RE: **Lomas Carwash Expansion**
9935 Lomas NE
Grading Plan Stamp Date: 3/27/19
Drainage Report Stamp Date: 3/27/19
Drainage File: J20D003

Based on the submittal received on 3/28/19, the grading plan and drainage report are approved for Grading Permit and Building Permit.

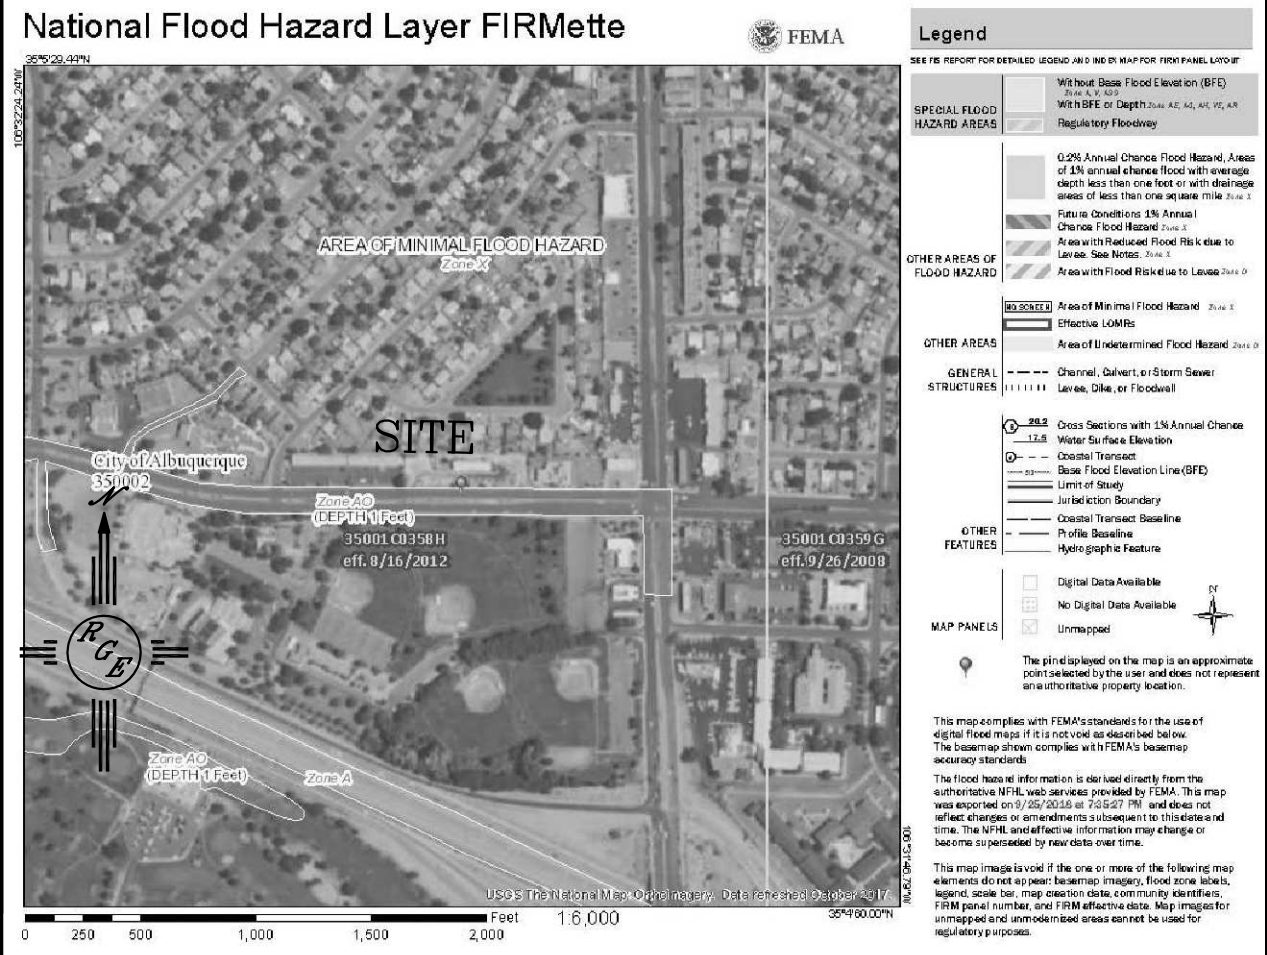
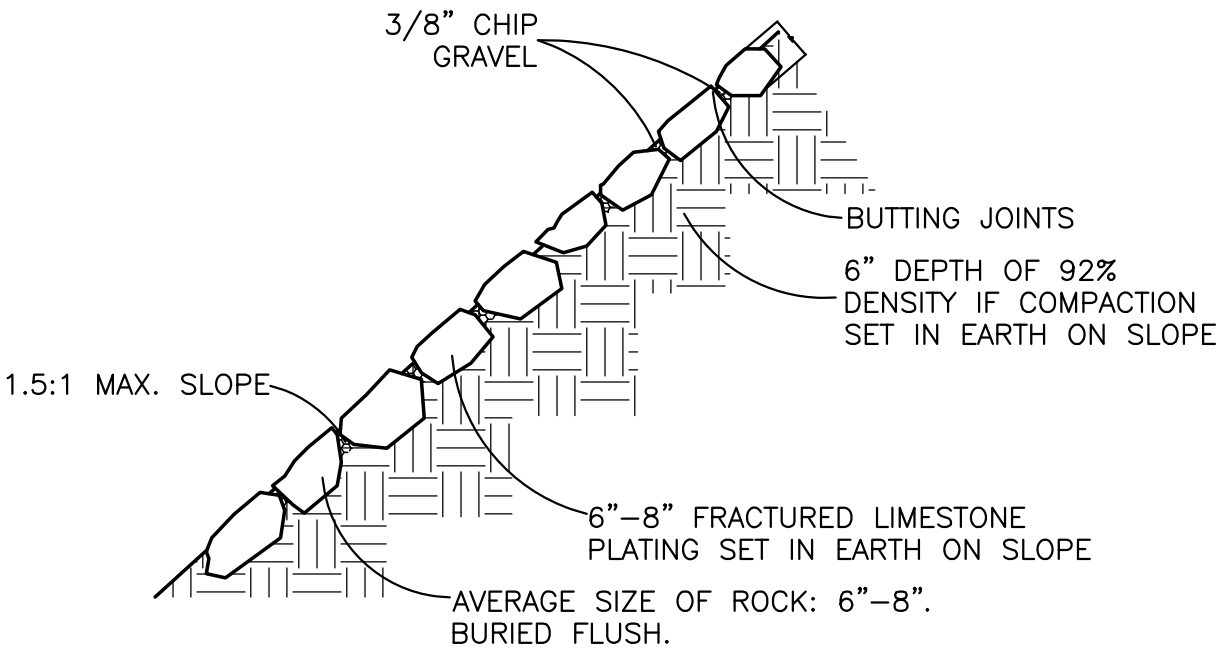
I need a copy of the drainage report with this (.pdf). Also, look at the south end of the berm- it's still at 28.5' and doesn't tie-in to the 29' contour; please correct and resend an .pdf.

The clients asked me to try to walk this thru, I said we don't do that but I would send email to the reviewer directly. The only change was raising the berm 1' and adding an overflow, the raising caused slope to exceed 3:1 so I added rock plating. Thank you
